Please ask for: Mrs D Johnson
Email: daun.johnson@arun.gov.uk
Telephone: 01903 737762
Our Ref: F/2/25/PL
Your Ref:
Date: 14th January 2025

Application for Planning Permission

Development: Change of use (conversion) of Studio 2 to residential accommodation to include its ancillary facilities including a new porch connecting to existing dwelling. This application is in CIL Zone 3 and is CIL Liable as a new dwelling.
Location: Newhouse Farm Barns The Mill Studio Ford Lane Ford BN18 0EF

STUDIOS 1 - 6: ELEVATIONS

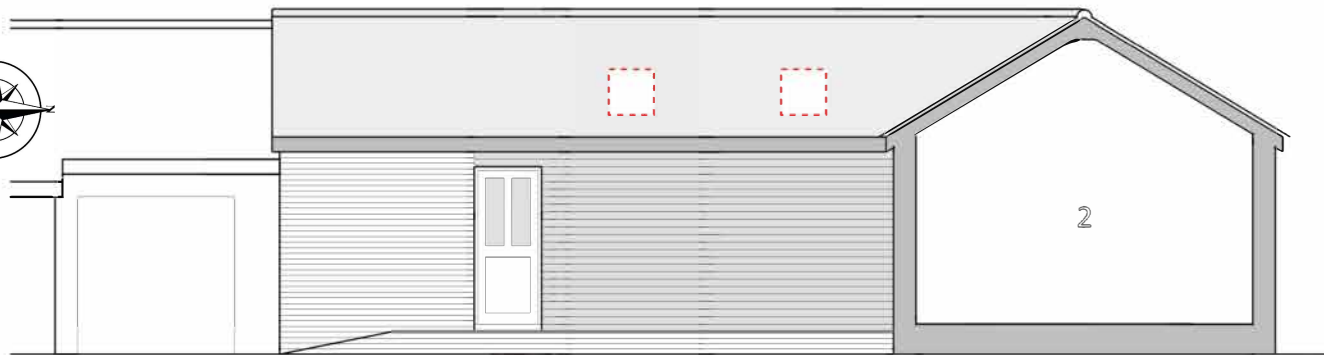
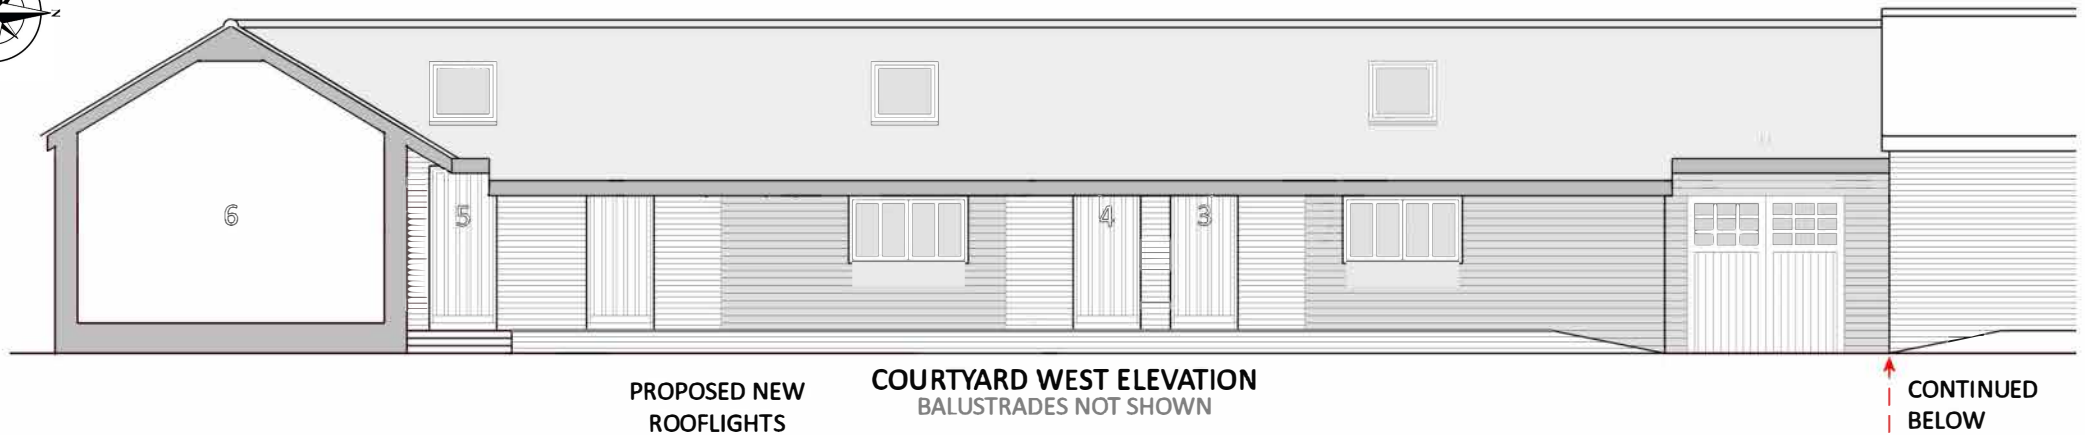
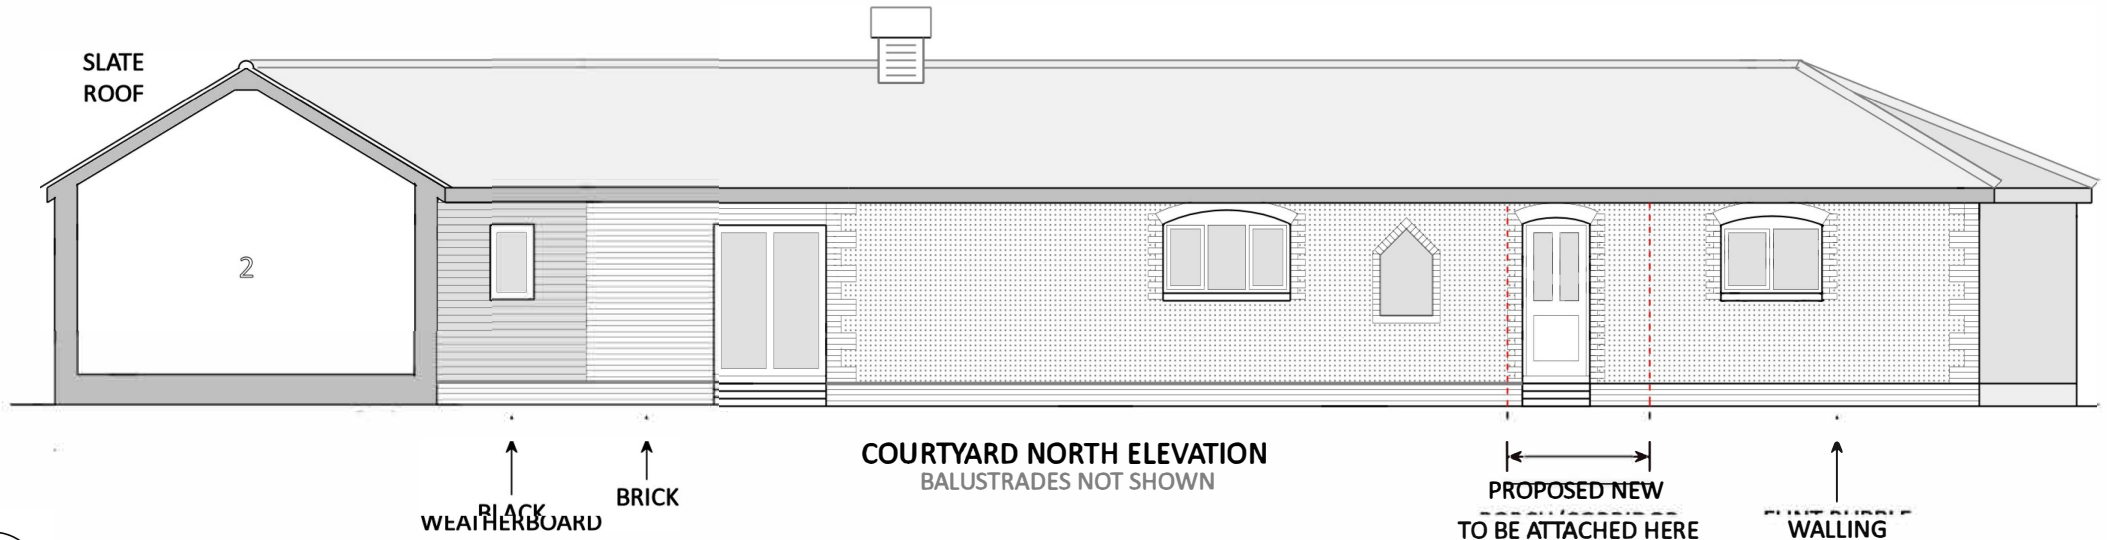
Please label the existing and proposed elevations as north, south, east or west as appropriate.
